Environmental Health Division
1675 W. Garden of the Gods Road
Suite 2044
Colorado Springs, CO 80907
(719) 578-3199 *phone*
(719) 578-3188 *fax*
www.elpasocountyhealth.org

Nelson Winery, AL-17-027

SITE PLAN

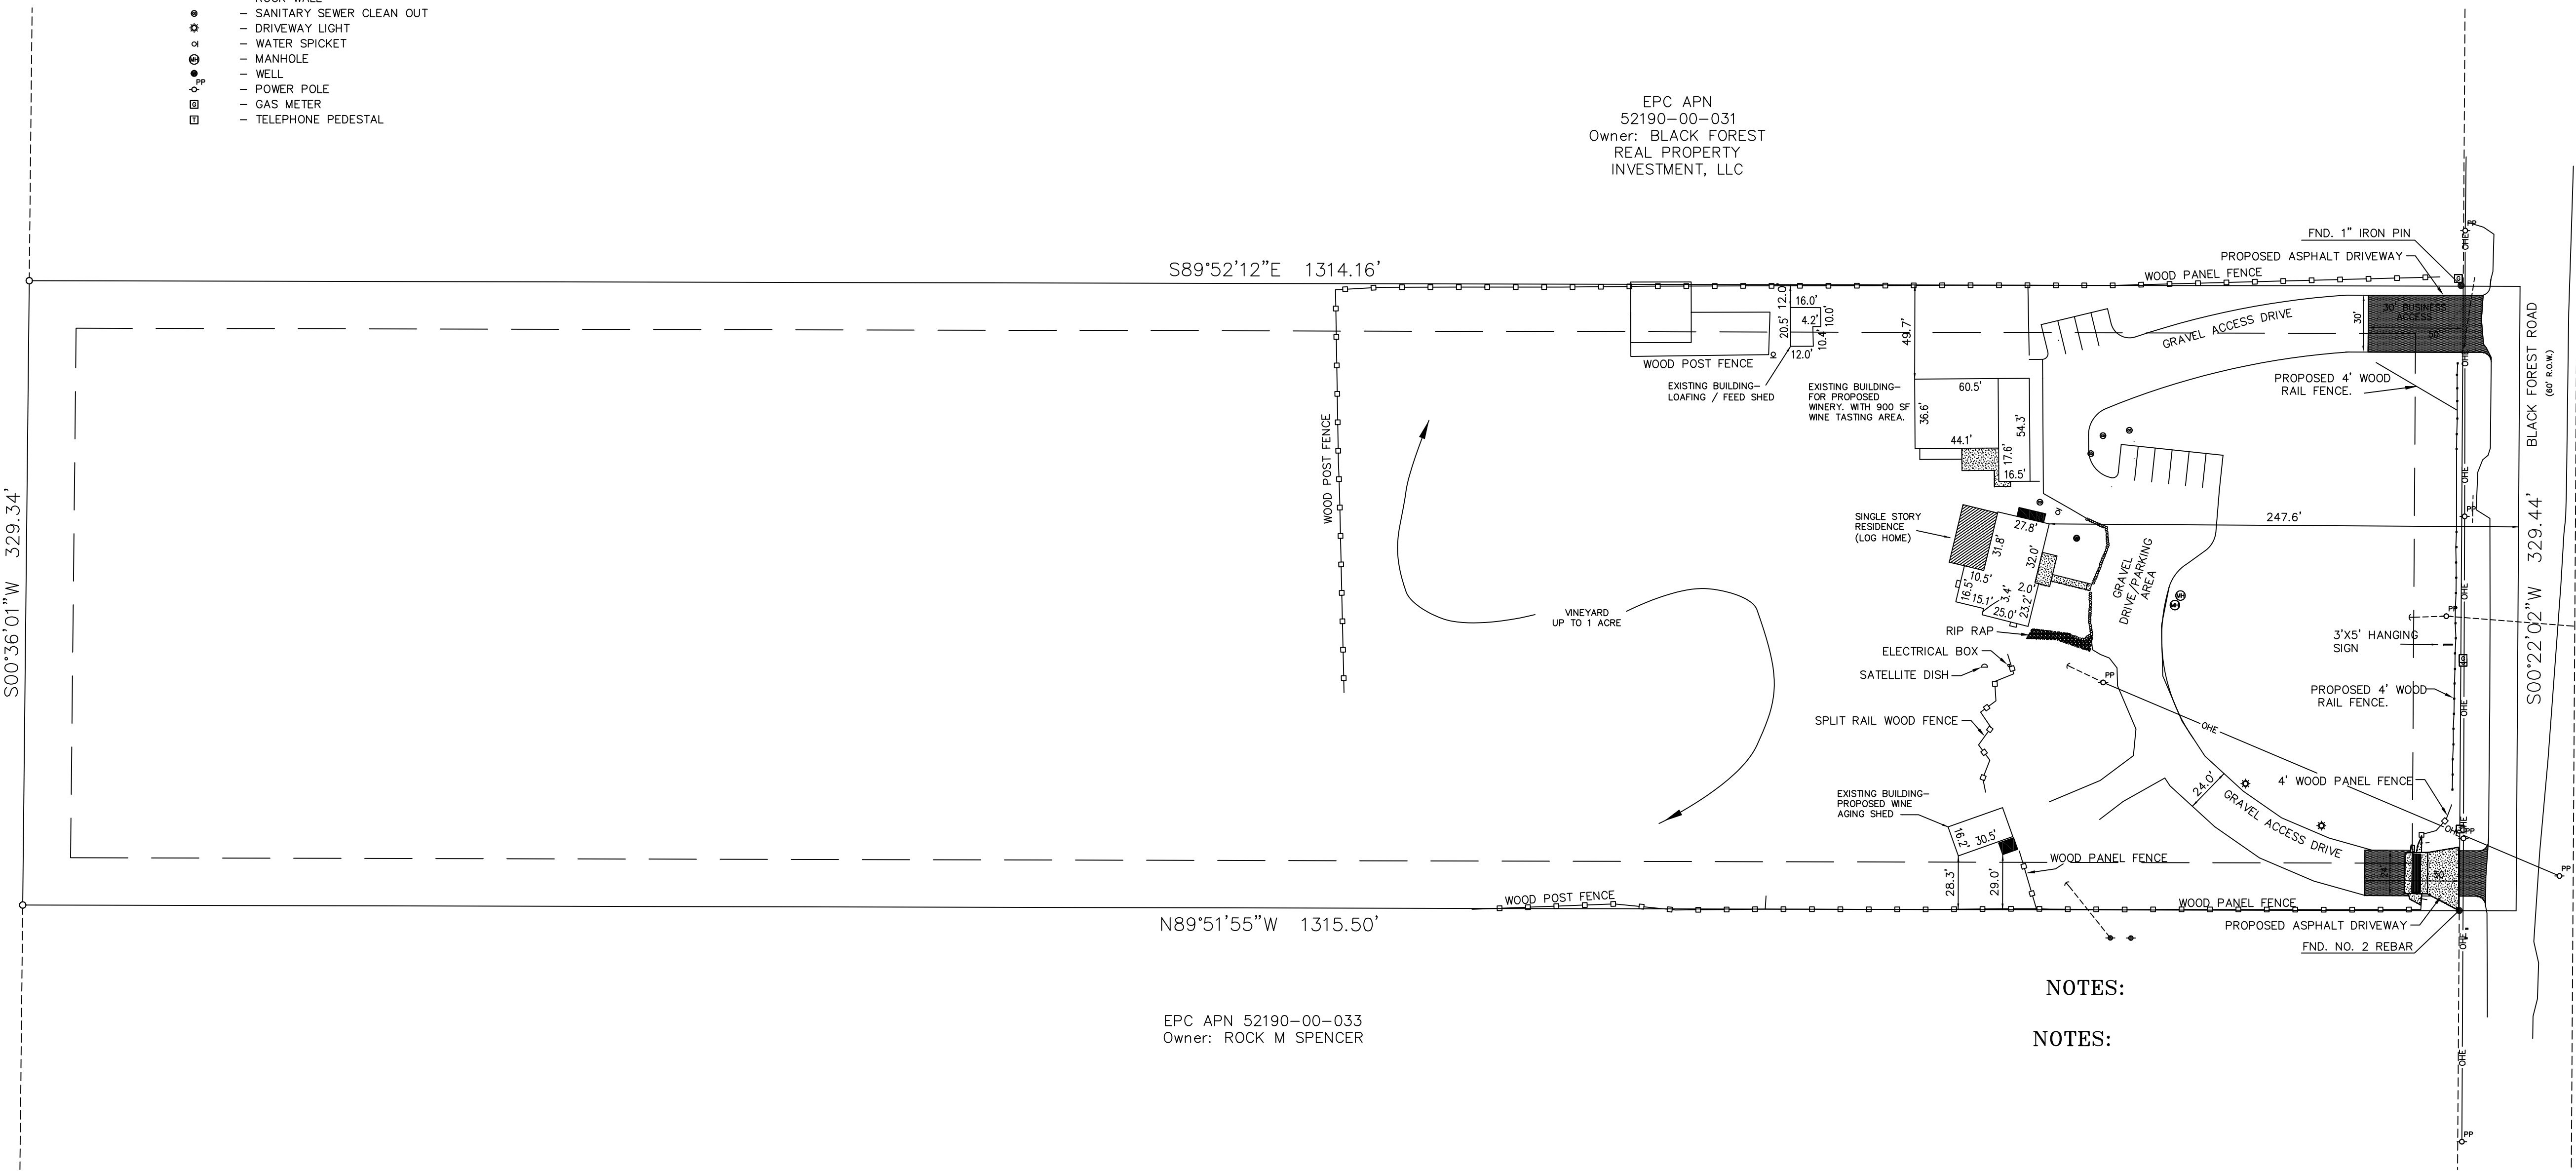
- **The proposed winery will require full compliance with the El Paso County Public Health, Onsite Wastewater Treatment System (OWTS) Regulations. The existing engineer designed OWTS must be evaluated by a registered professional engineer for the proposed change in use.**
- **The water system may meet the definition of a community water system at some point based on the proposed operational plan outlined in the letter of intent. Contact El Paso County Public Health for information.**
- **Plans for the food and wine preparation areas must be submitted to El Paso County Public Health for review and approval. A Retail Food Establishment License may be required depending on the extent of food preparation at the site. Contact El Paso County Public Health for information.**
